Application for a non-material amendment following a grant of planning permission.

Number	14
Suffix	
Property name	
Address line 1	Davenport Road
Address line 2	
Address line 3	
Town/city	Felpham
Postcode	PO22 7JR
Description of site location must be completed if postcode is not known:	
Easting (x)	495422
Northing (y)	99519
Description

Hip to gable loft conversion with juliet balcony, alterations to fenestration/openings and external facade.

Reference number:	FP/113/21/HH
Date of decision	19/07/2021

Dwg No. 21009-P-107-E

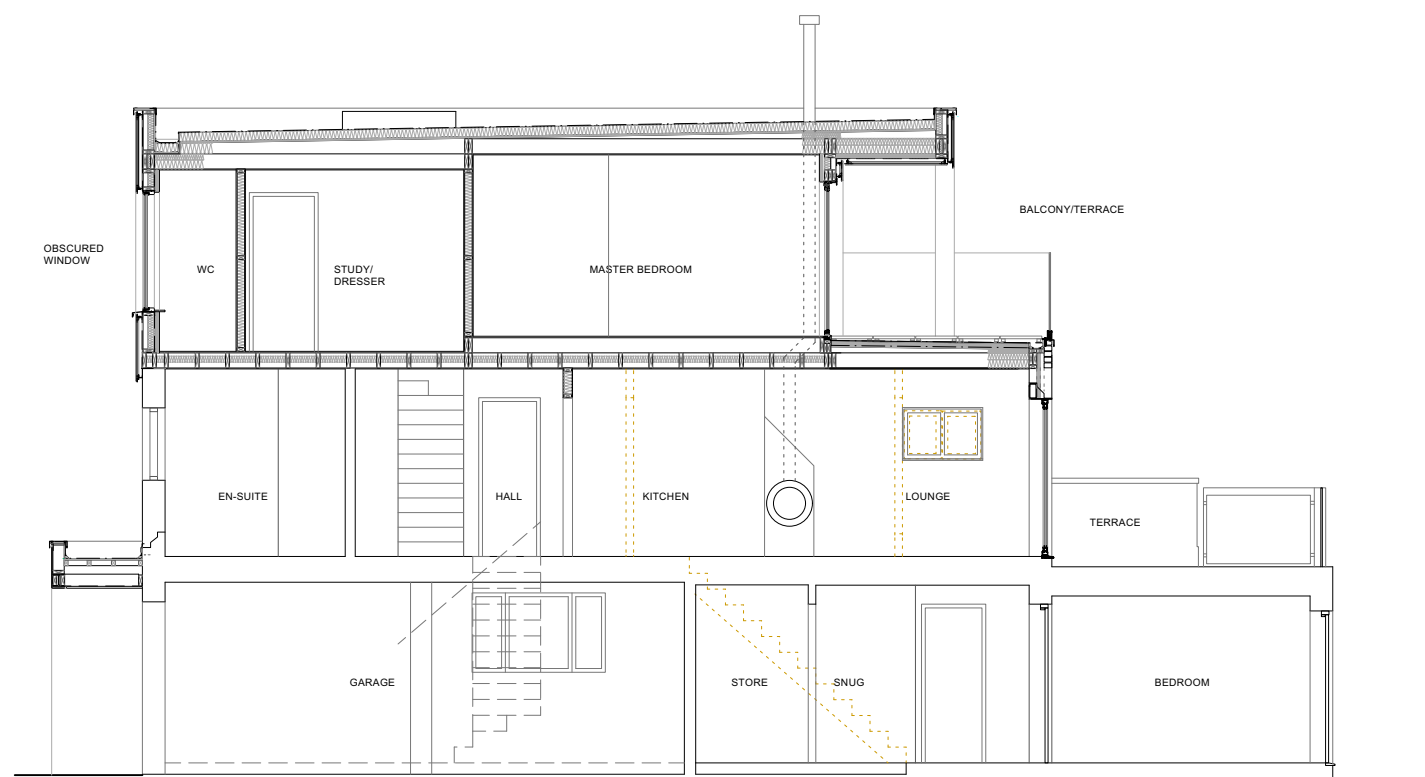
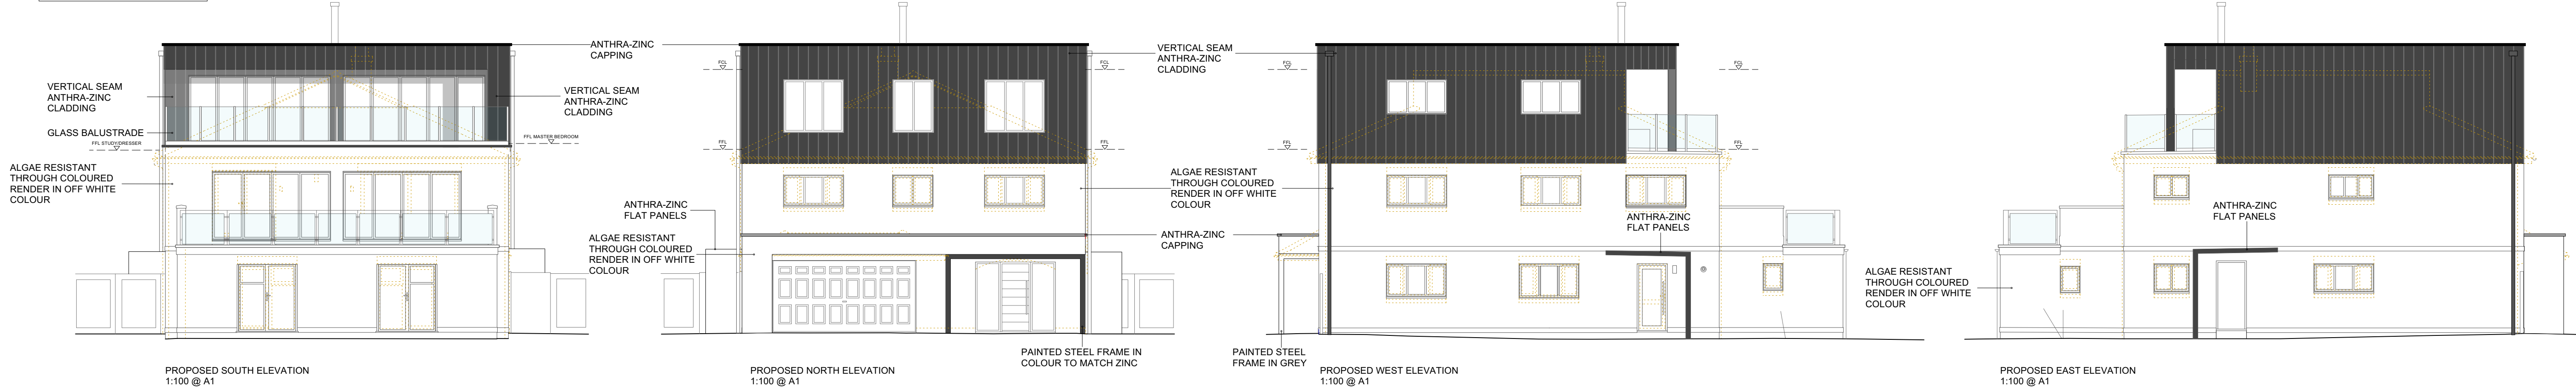
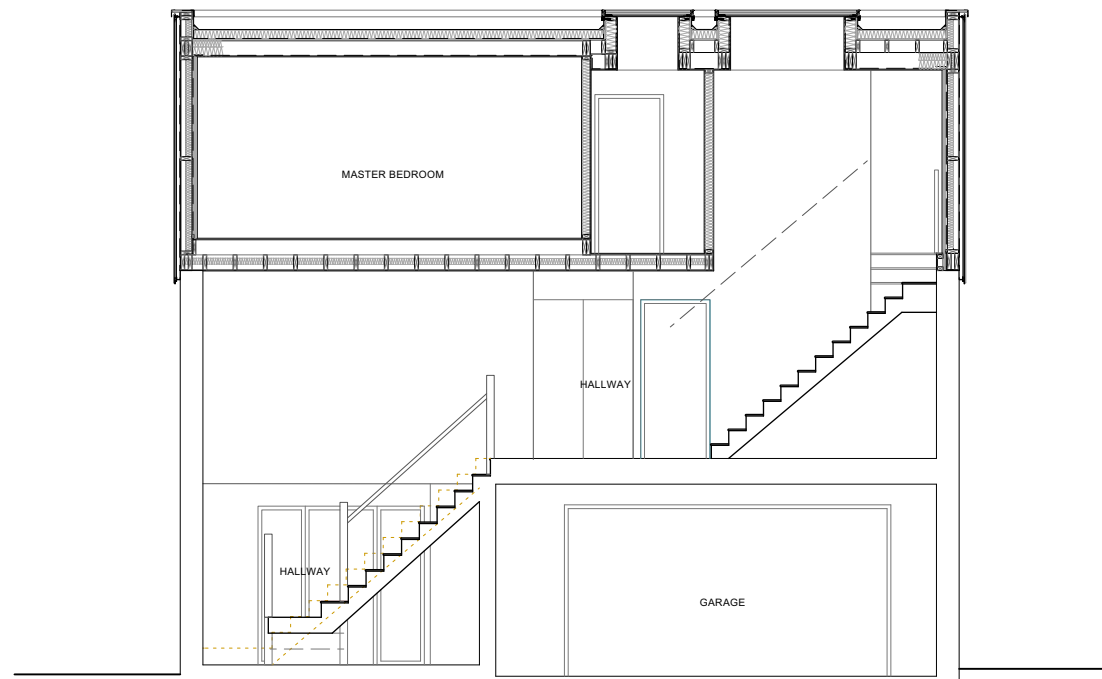
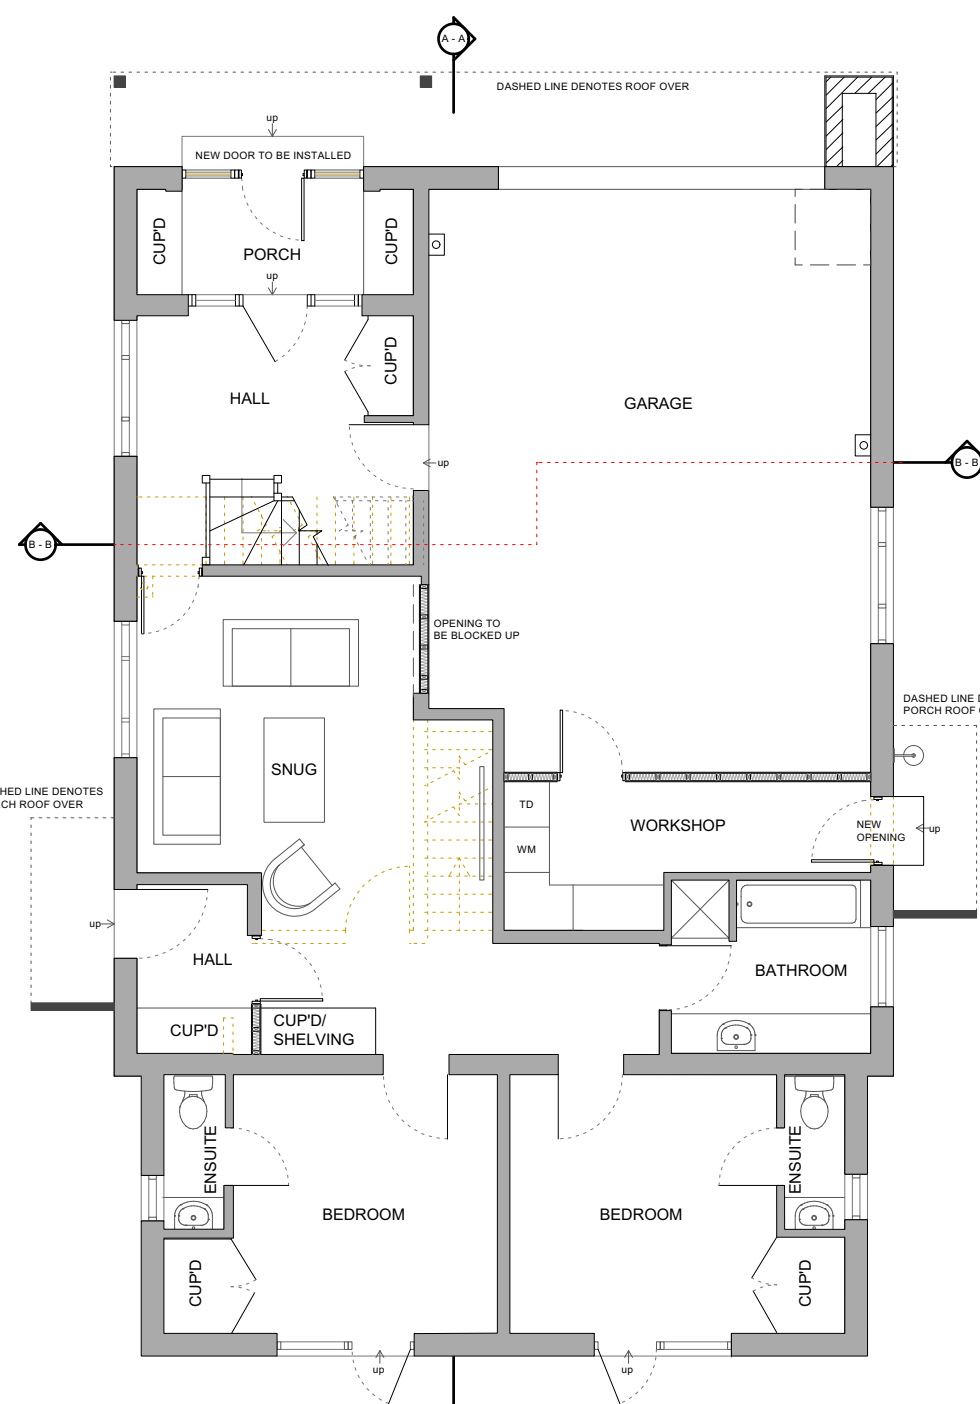
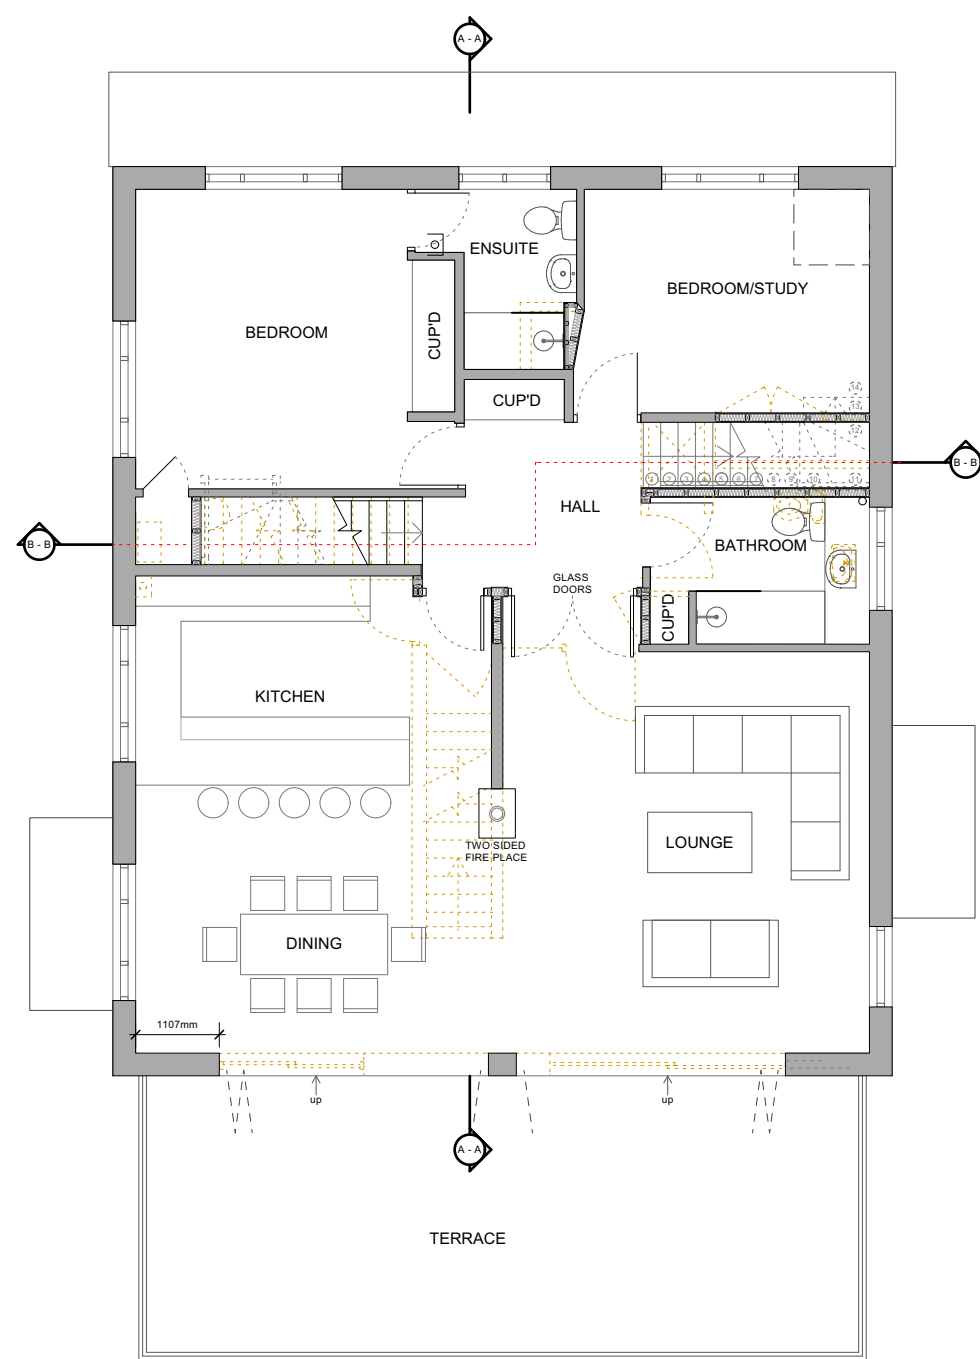
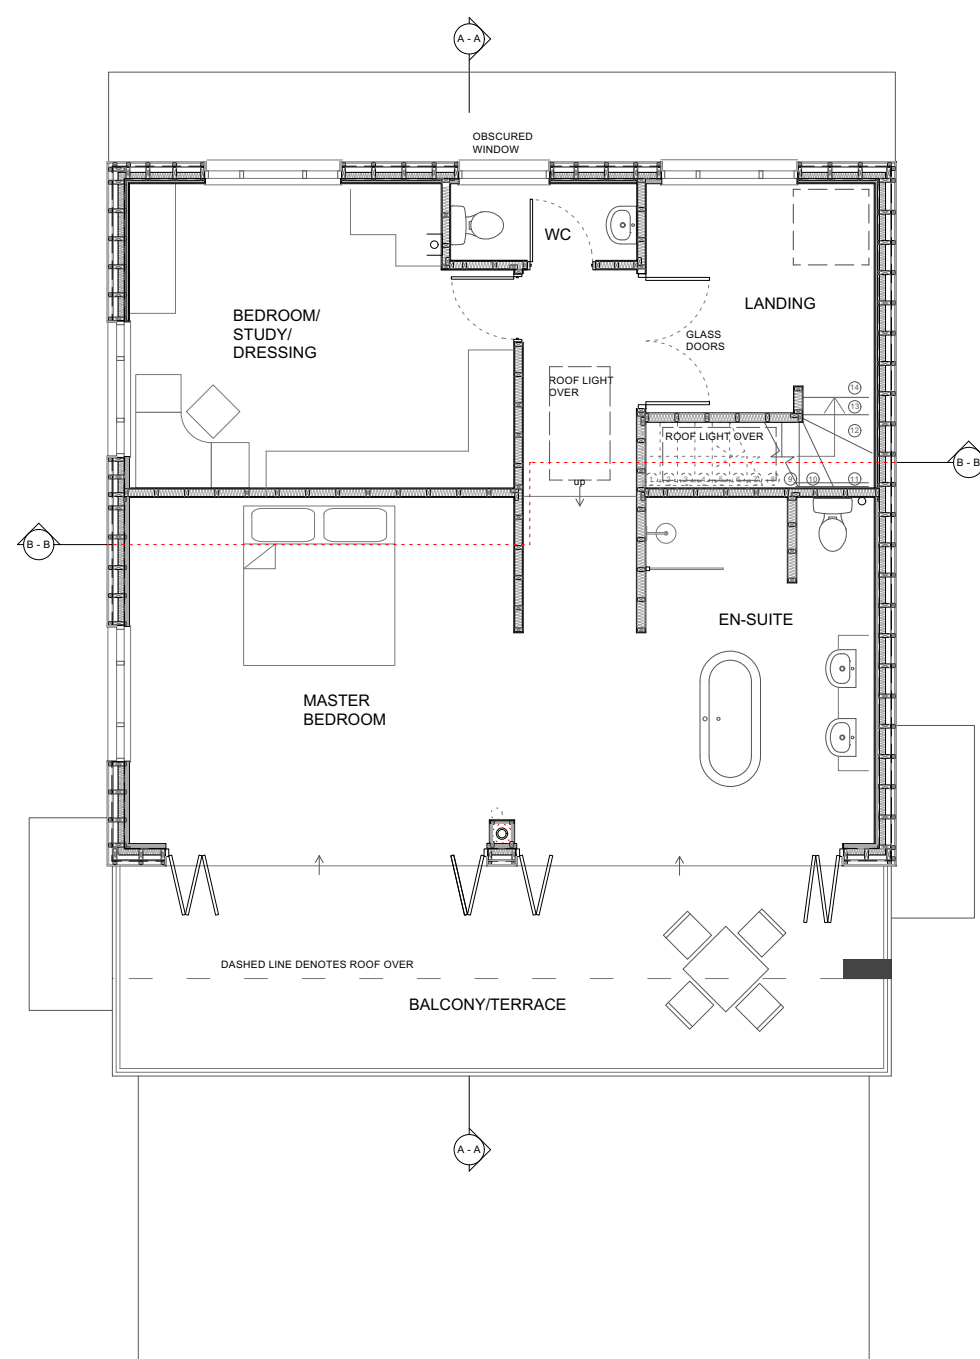
Increasing structural openings of the windows on the first and second floors on the south elevation. Raising second-floor balcony.

The windows are widened to create symmetry and balance the elevation. The balcony is raised to allow for level access from the master bedroom.
